Re: Inspection of Repairs  
295 Wood Rd.  
Dunn, NC

At your request, the undersigned visited the subject property on November 21, 2019 to inspect the home addition being constructed at the subject property. The report that follows has been prepared based on that inspection.

FLOOR PLAN DRAWN BY ARTHUR BARNES 11-18-19
 SCALE - 1 INCH EQUALS 40 INCHES ALL MEASURES
 ARE IN INCHES

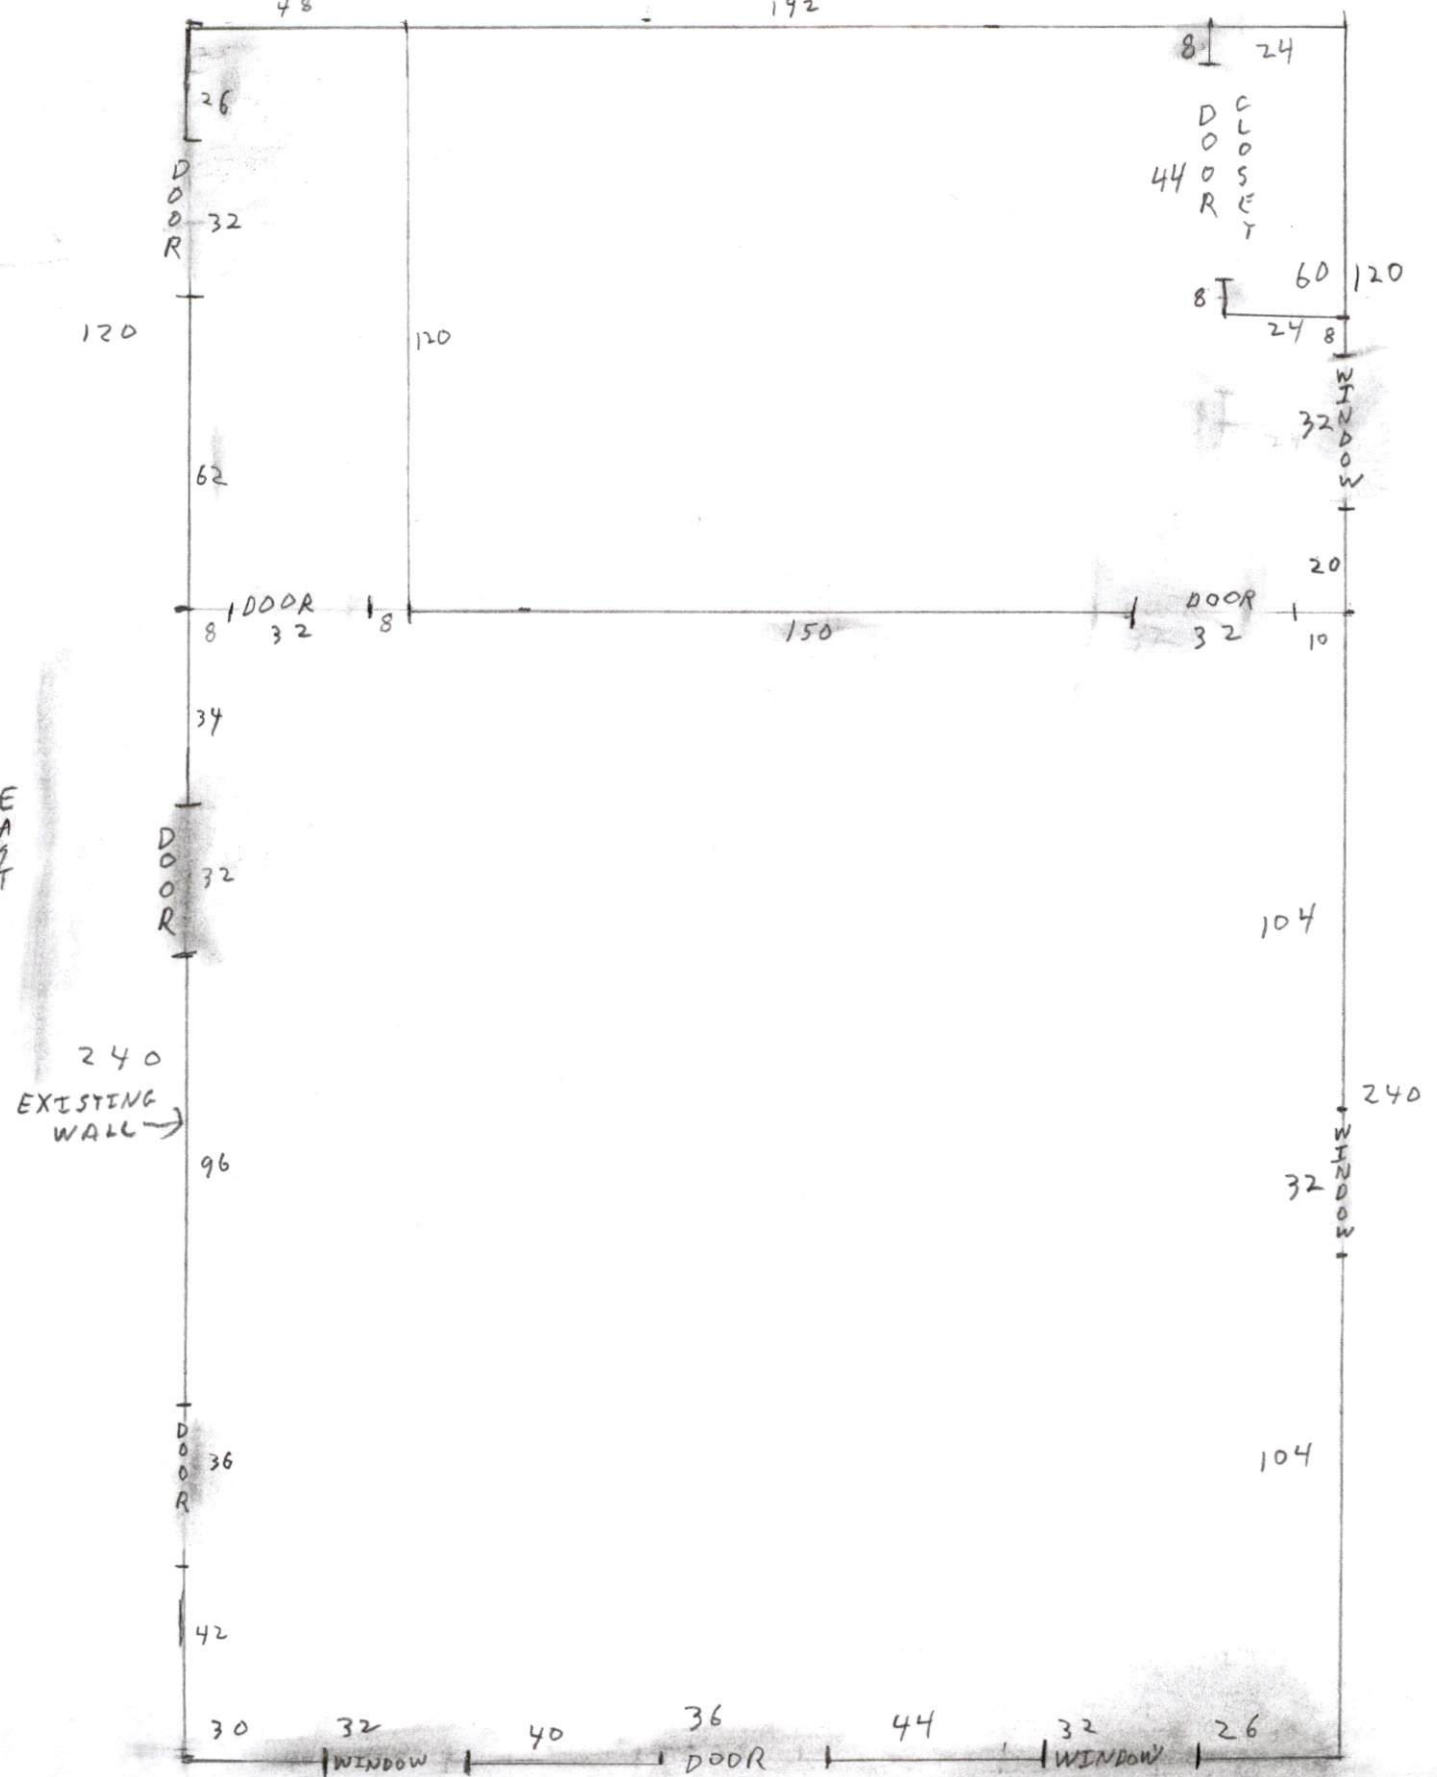
After analysis, it was determined that the 3-ply 2x8 girders supporting the floor framing are inadequate to support the anticipated loads. We have provided a recommendation below to address this issue.

The CMU block piers in the crawl space have the CMU blocks turned on their side. This orientation of the CMU blocks has placed them in their weak axis and is therefore not properly supporting the floor framing above. We have provided recommendations below to address this issue.

2. We recommend installing new 8"x16" CMU block piers at all midspans of the floor girders. This will total to (4) new CMU piers. The piers shall be supported by a new 12"x20"x8" thick concrete footing installed a minimum of 8" below grade. After this repair the floor girders will be structurally adequate.

3. We recommend one of the following repairs to address the CMU block piers with the blocks turned on their weak axis:
  - a. Temporarily supporting the floor framing and rebuilding the block piers with the blocks stacked along their strong axis.

- b. Installing new 8"x16" CMU block piers directly adjacent to the existing piers, and directly under the floor girders. At the (2) existing center piers, a new 8"x16" block pier should be installed on both sides, under the girder. The new piers should be supported by a concrete footing as described in recommendation #2. If the existing footing projection is sufficient, the new piers may be placed on the same footings as the existing piers.

ROOF LINE DRAWN BY ARTHUR BARNES 11-18-19
SCALE - 1 INCH EQUALS 40 INCHES

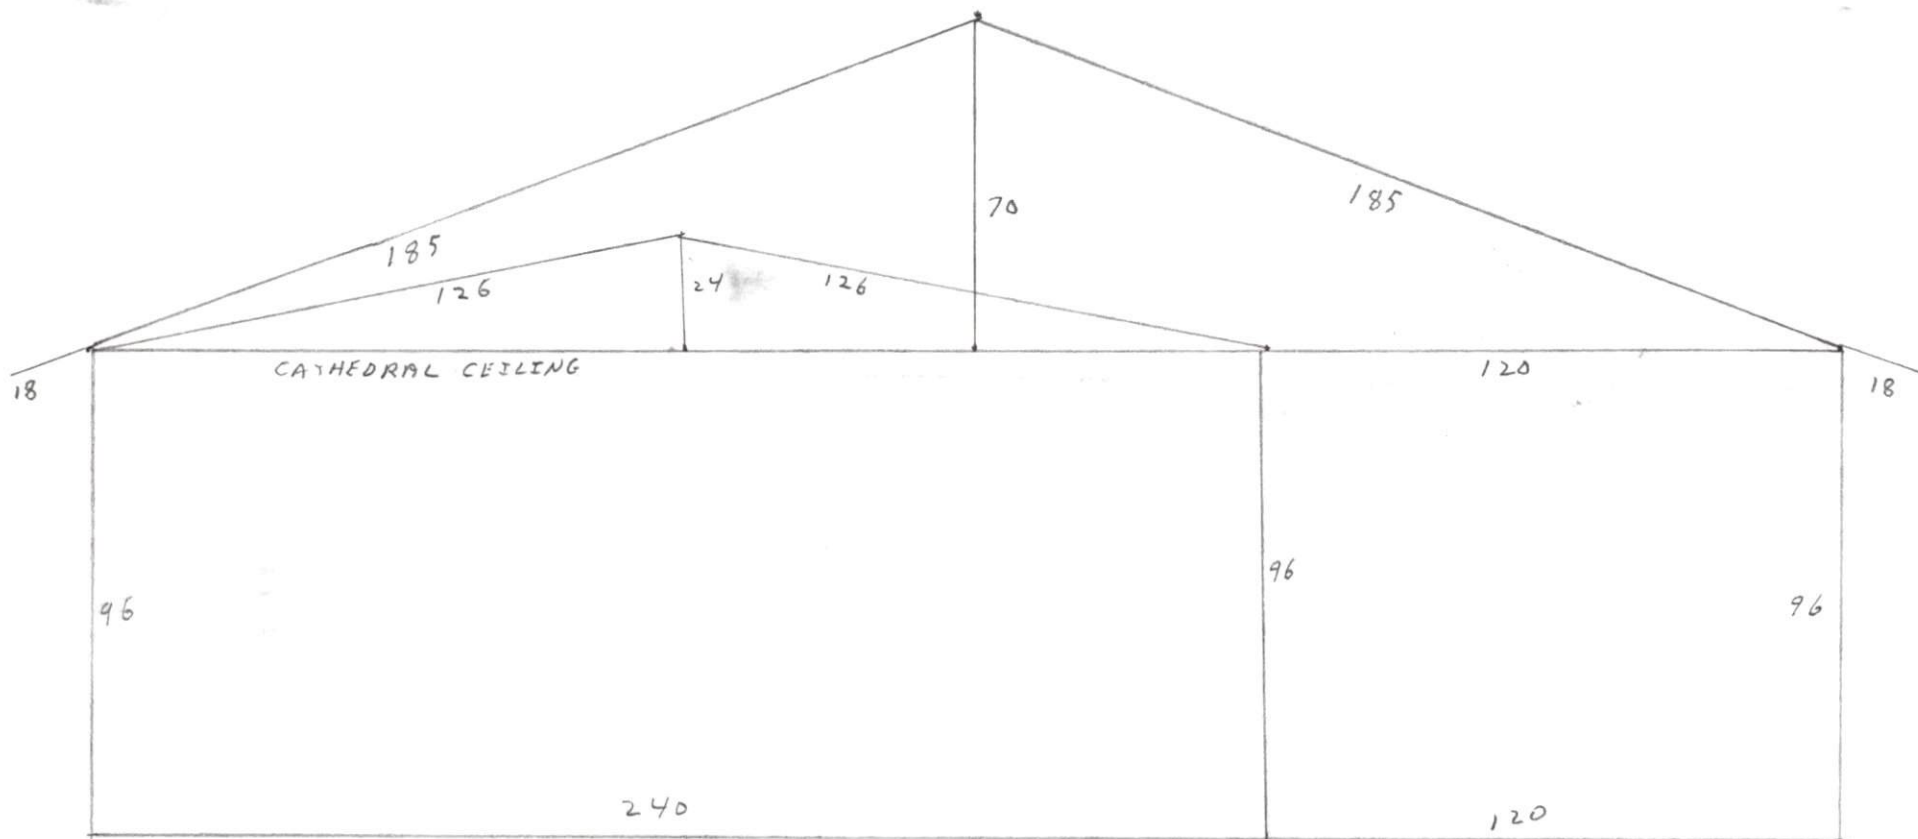
The vaulted ceiling construction doesn't allow for the rafter loading to be adequately supported. The vaulted section on the front side of the home addition does not make use of a structural ridge beam. Since there is no ridge beam supporting the load from the rafters, the loads should be carried through ceiling joists or rafter ties per the 2018 NC Building Code: Residential Code. The vaulted ceiling construction doesn't allow for the rafter loading to be adequately supported, and repairs are required. We have provided recommendations below to address this issue.

1. We recommend installing new 2x6 rafter ties horizontally at the top of the vaulted ceiling section. The new rafter ties shall be installed at a maximum of  $1/3^{\text{rd}}$  of the vertical distance between the top of the supporting walls and bottom of the roof ridge. The ends of the new rafter ties shall be fastened to the rafters with a minimum of (9) 16d nails. Also, the end of the 2x8 ceiling joists at the rear of the vaulted section shall be fastened to the 2x6 ceiling joists in the rear section with a minimum of (9) 16d nails.
